186827 PA/2016/649 Creation of habitat, Halton Marshes

Date: 09 September 2016
Our ref: 193994
Your ref: PA/2016/649

**Planning consultation: Planning permission for creation of habitat, primarily wet grassland
Location: Land to the East of Skitter Road, Halton Marshes, East Halton**

- ALL DIMENSIONS ARE IN MILLIMETRES, ALL LEVELS, CHAINAGES AND CO-ORDINATES ARE IN METRES UNLESS OTHERWISE STATED.

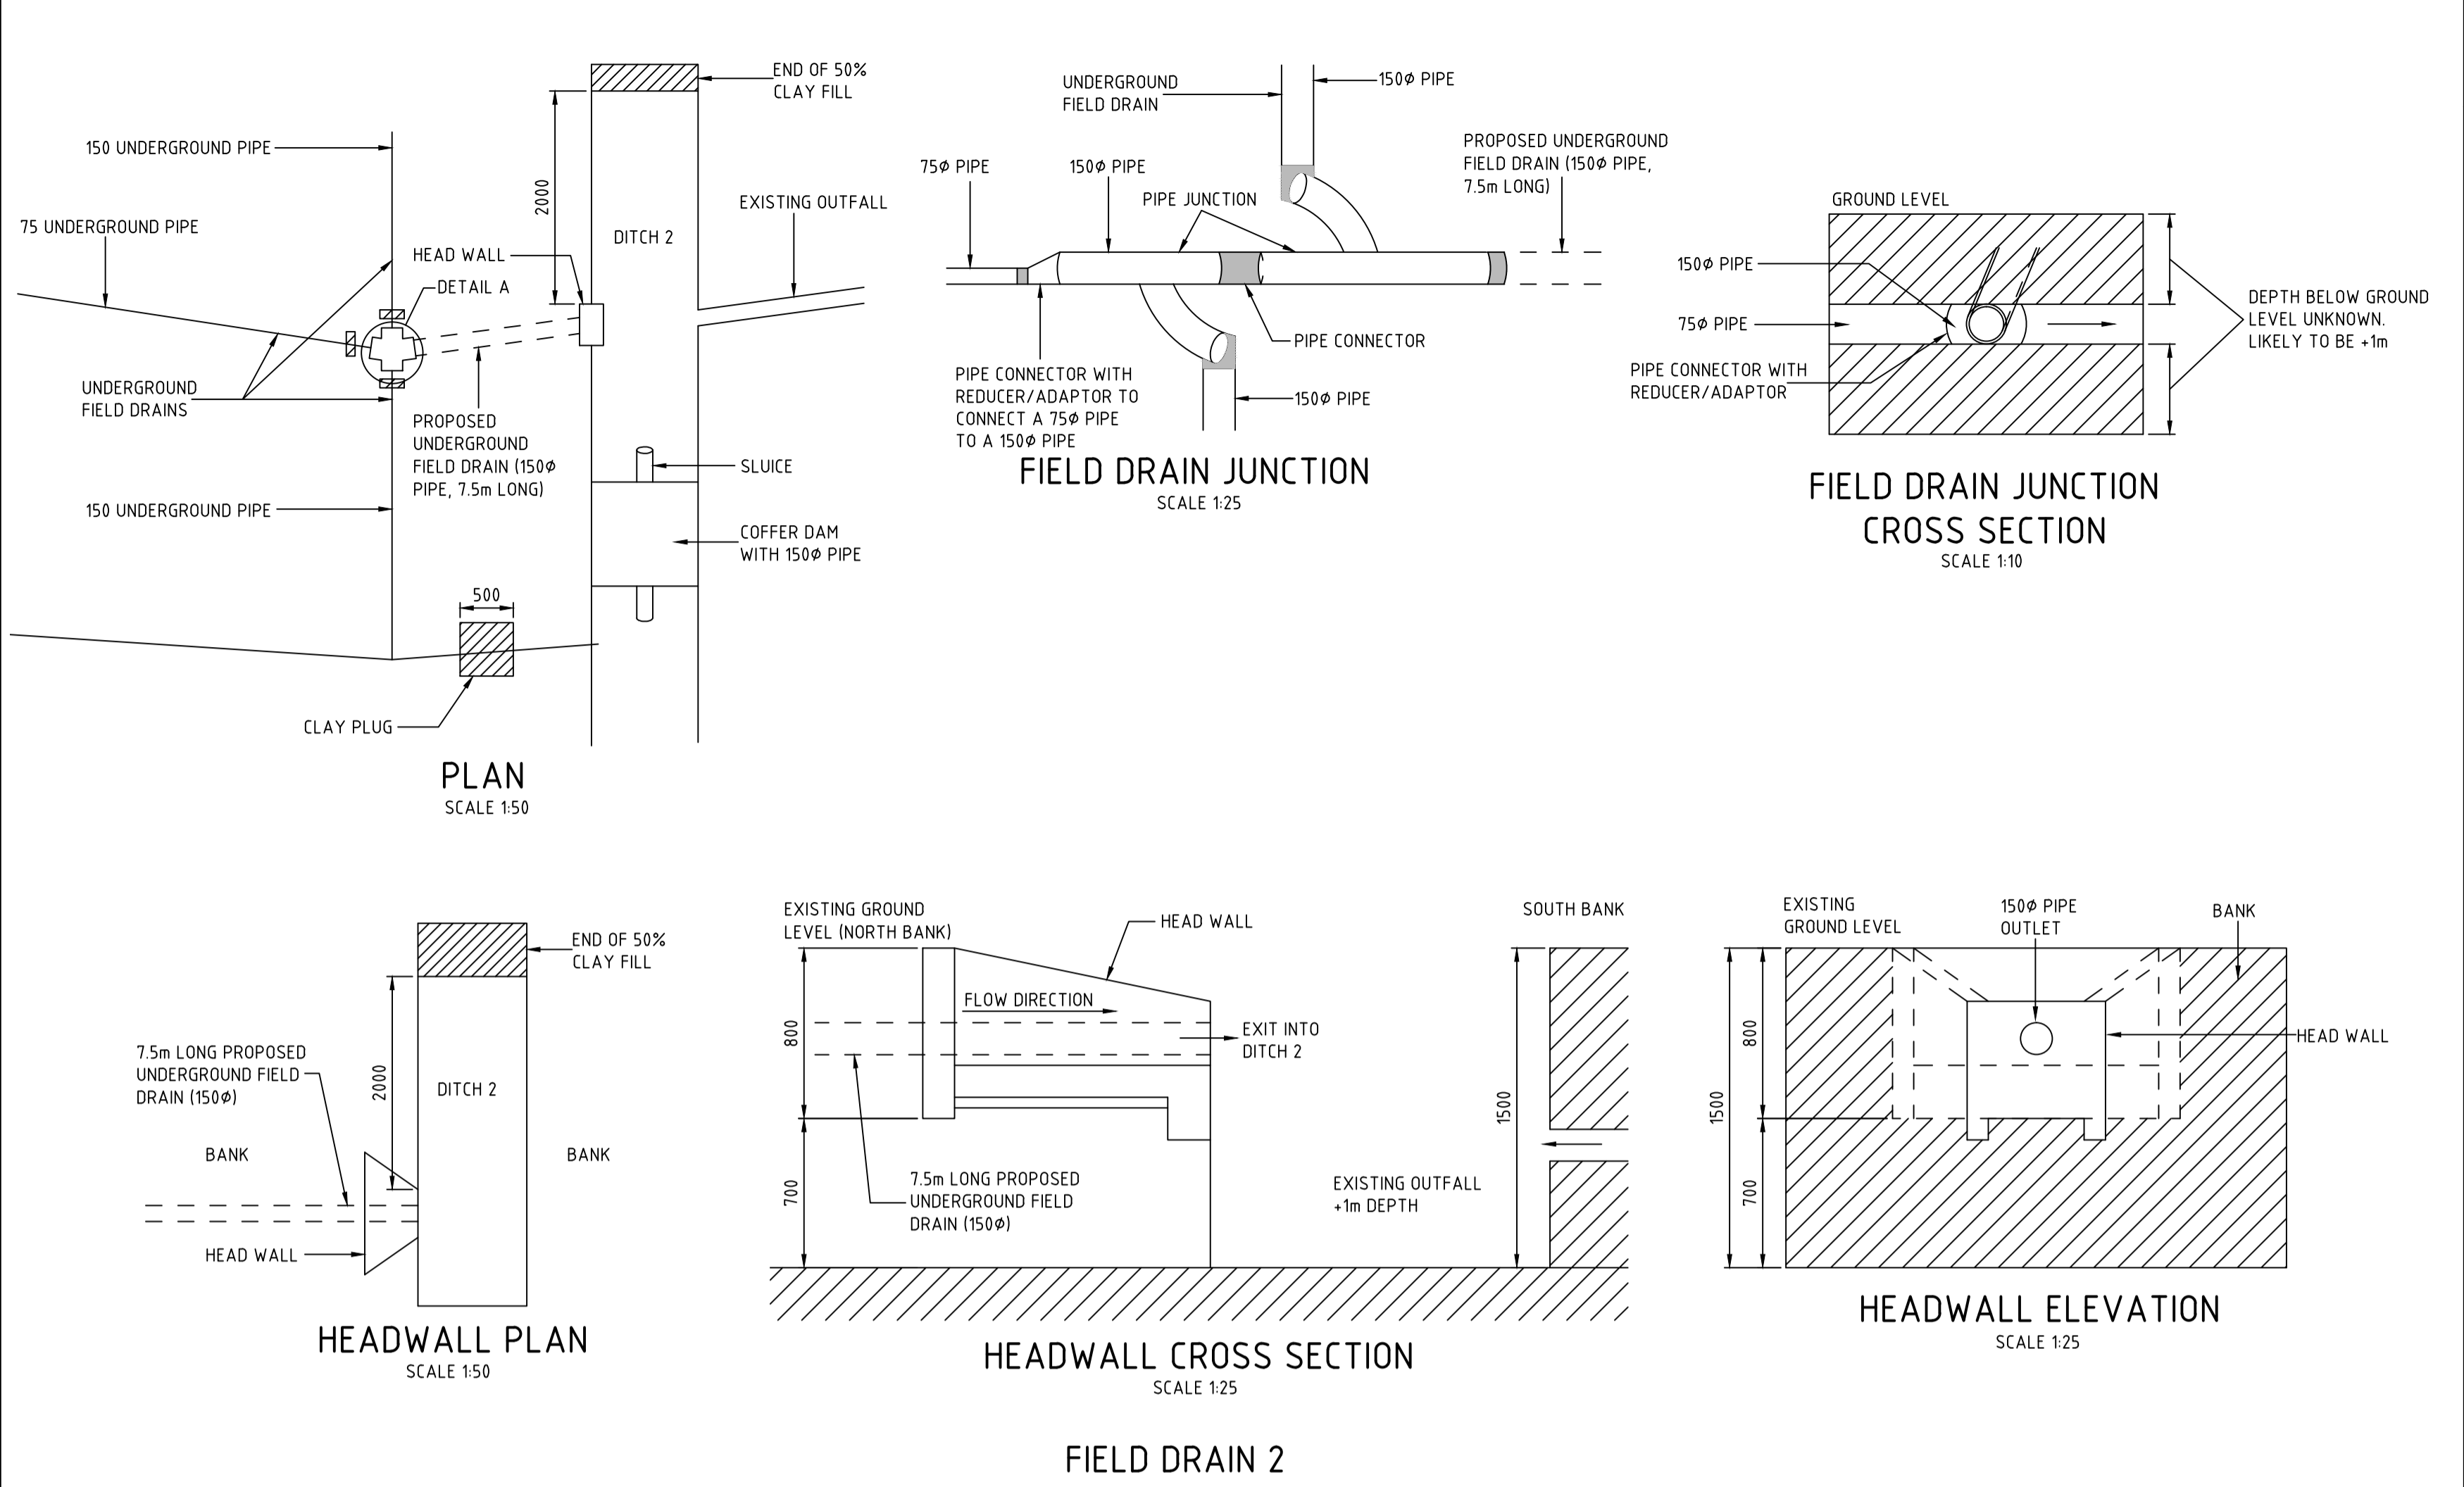
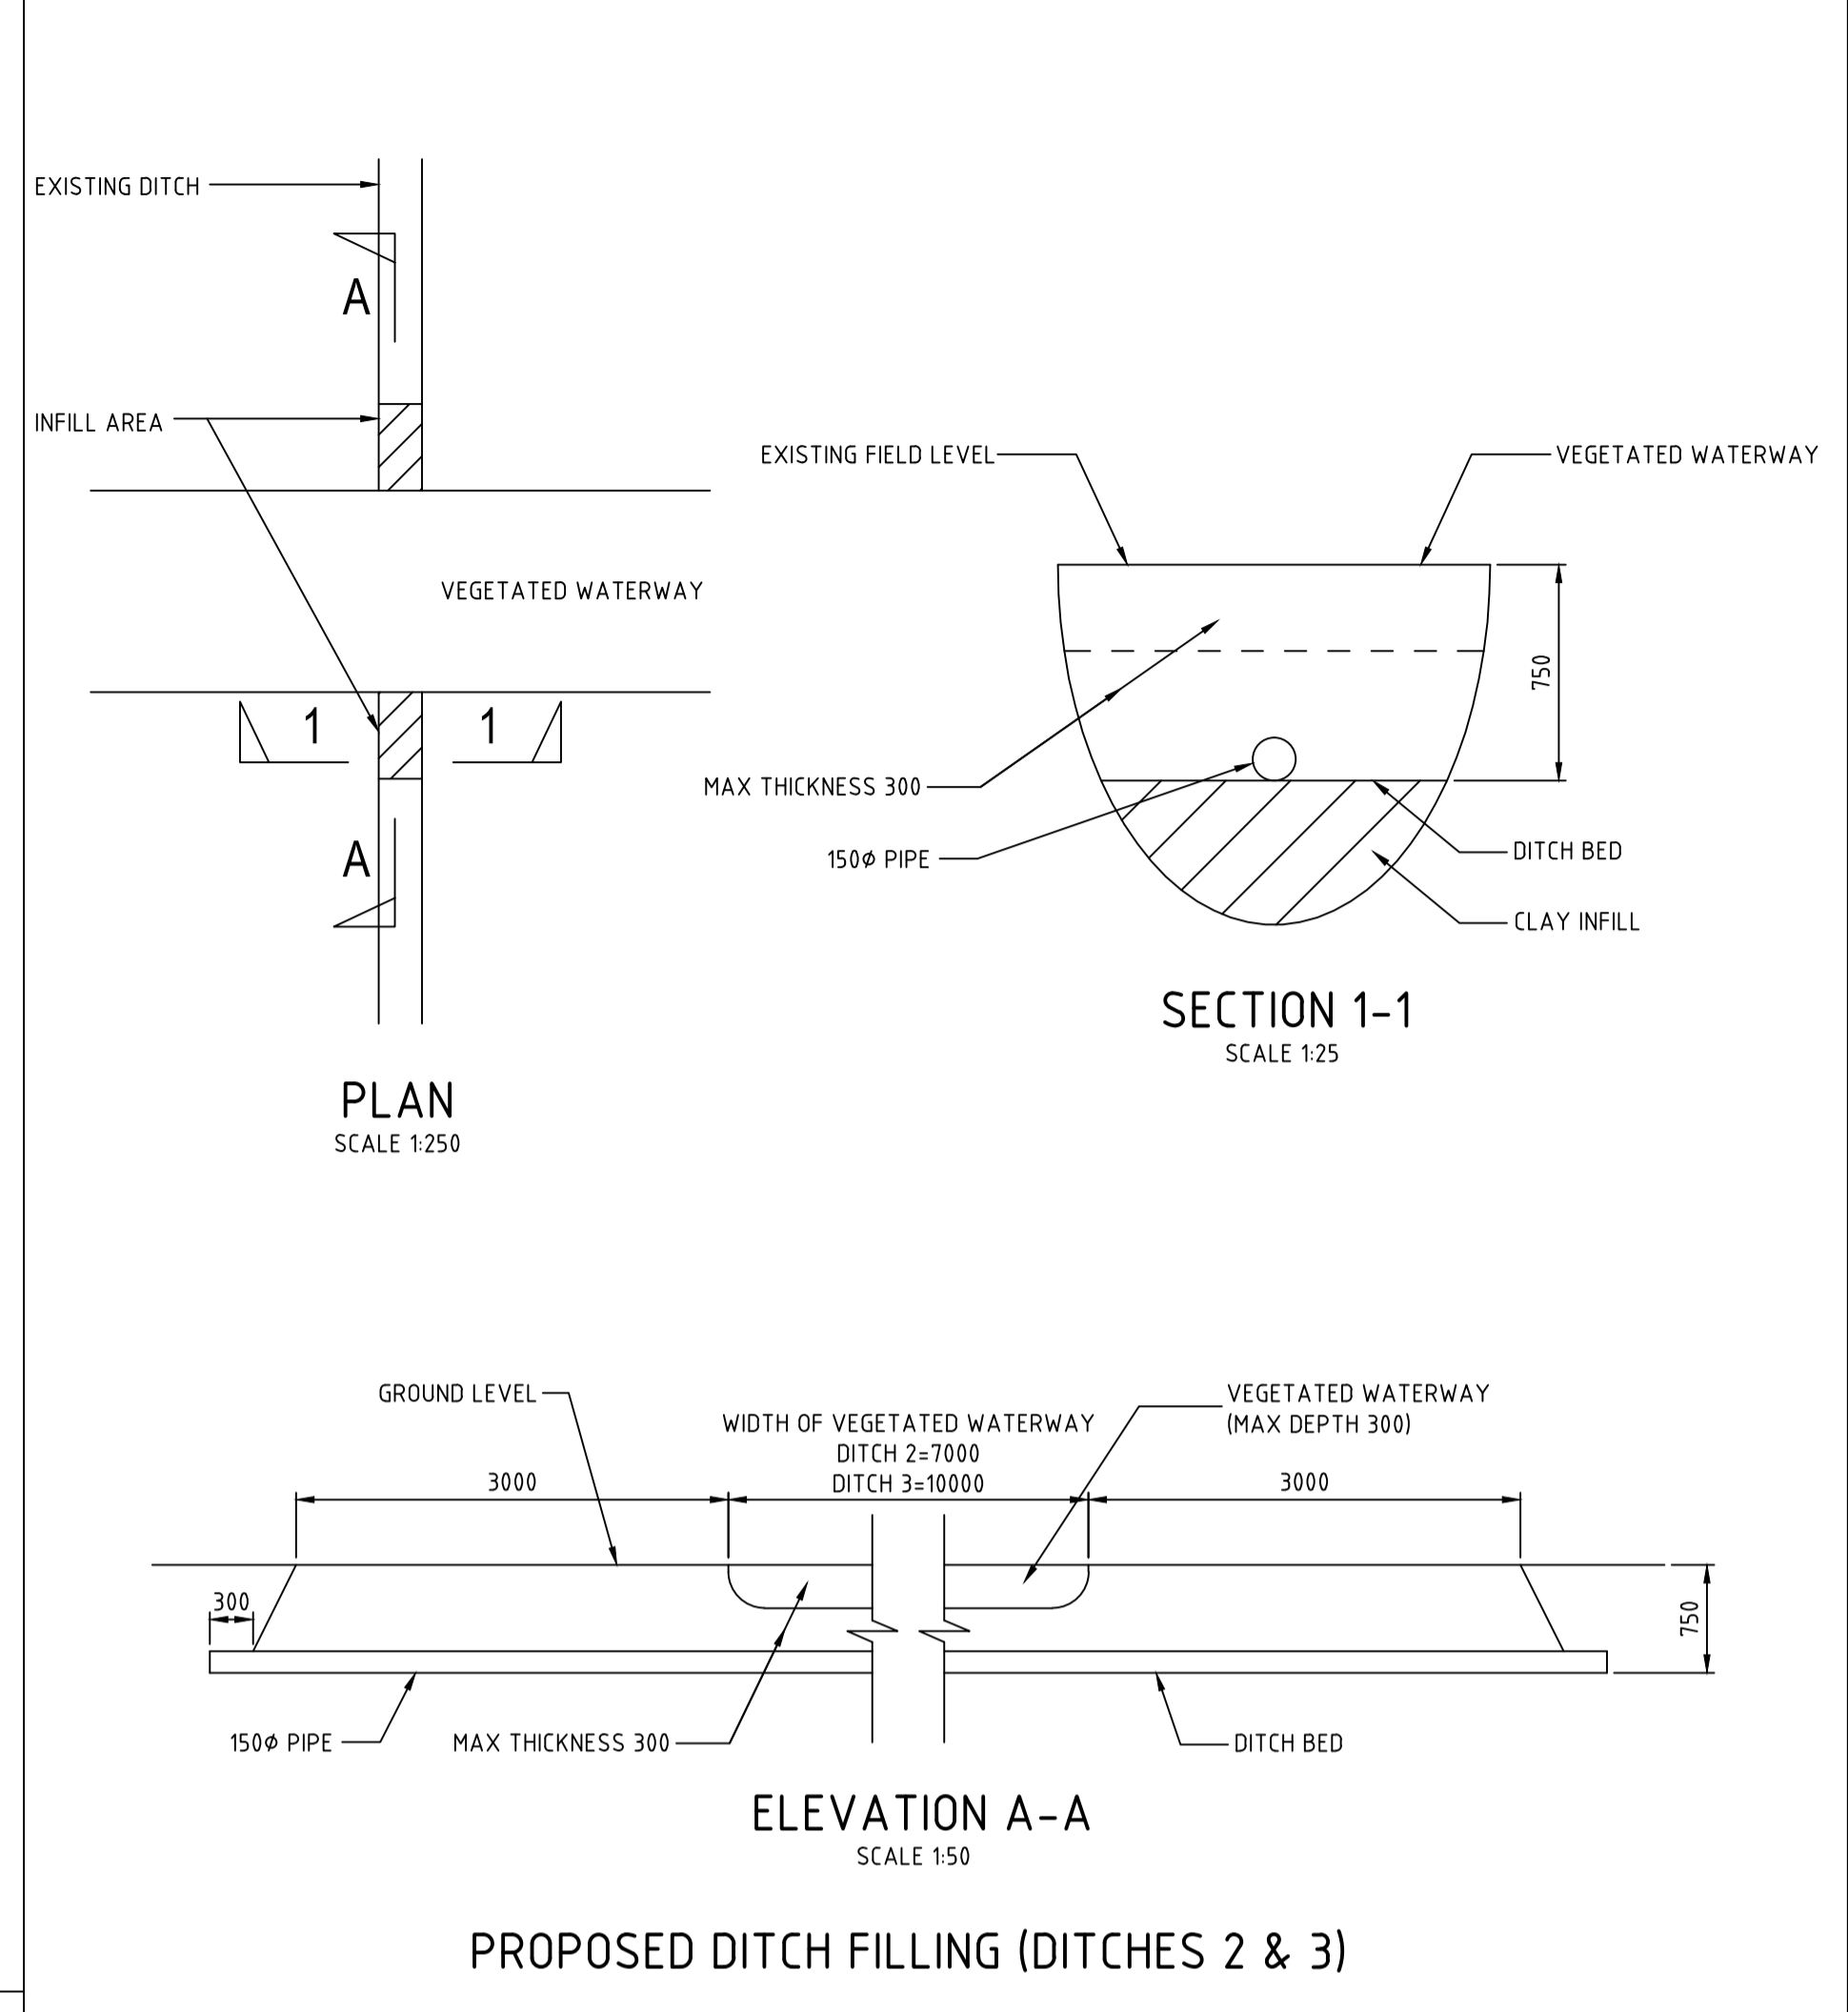
- It would be helpful if the location of the wind pump could be shown on this drawing and all other relevant drawings.
